From: Holt, Kelly <Kelly.Holt@lancashire.gov.uk>
Sent: 22 August 2018 17:44
To: planning
Subject: D3.2018.0713 – Land at Mill Lane, Gisburn

D3.2018.0713 – Land at Mill Lane, Gisburn

Application for the discharge of condition 3 (materials), 4 (windows), 5 (bat and bird boxes), 7 (boundary treatments), 8 (levels), 9 (site access), 10 (visibility splay), 11 (landscaping), 12 (protective fencing to trees), 13 (lighting), 14 (foul and surface water), 15 (surface water) and 16 (construction method statement) from planning permission 3/2017/0750

Rev	Description	Date
Project	Mill Lane, Gisburn.	
Status	Planning Application	
Client	Westbridge Developments	
Drawing Title	Site Layout	
Project No	010-509	
Orig No	07	
Scale	1:200 @ A1

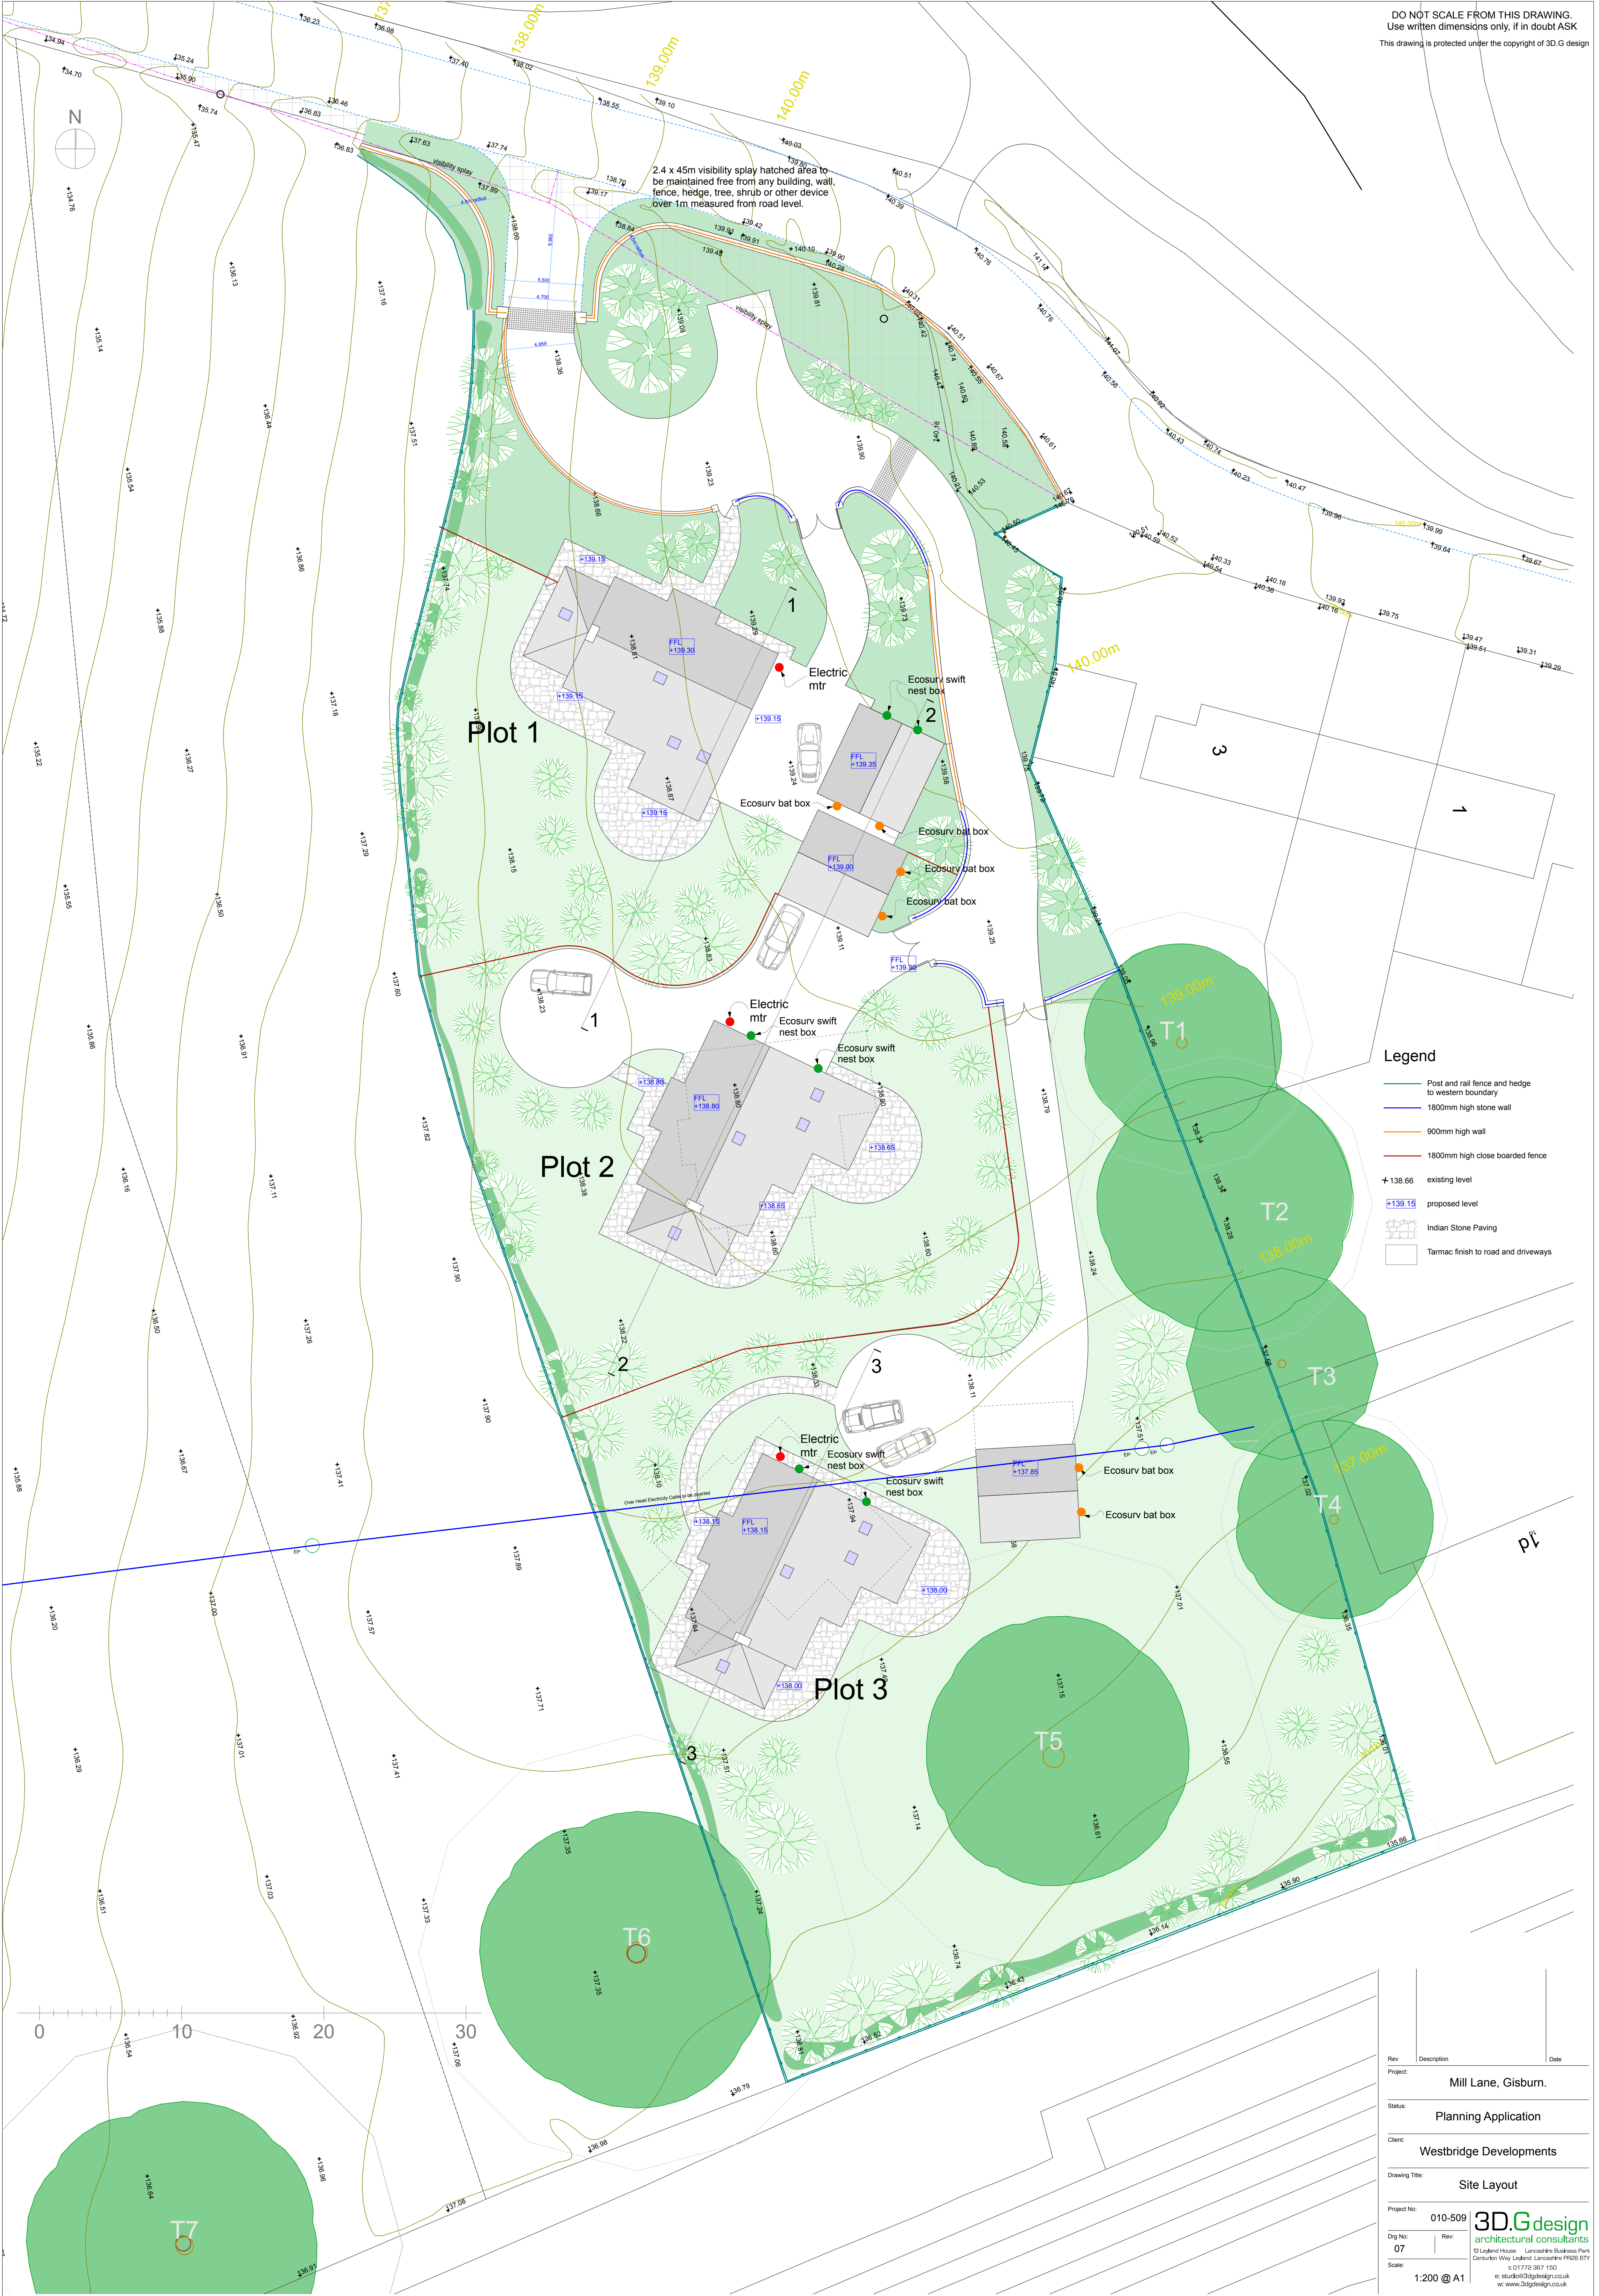
Condition 10 – The required visibility splay of 2.4m x 45m is shown on the site layout plan and therefore this condition can be discharged.

Condition 16 – The temporary gates at the site access should be set back sufficiently to allow the longest delivery vehicle to clear Mill Lane whilst the gates are operated. Currently the plan shows 6 metres and a distance of 10 metres is recommended.
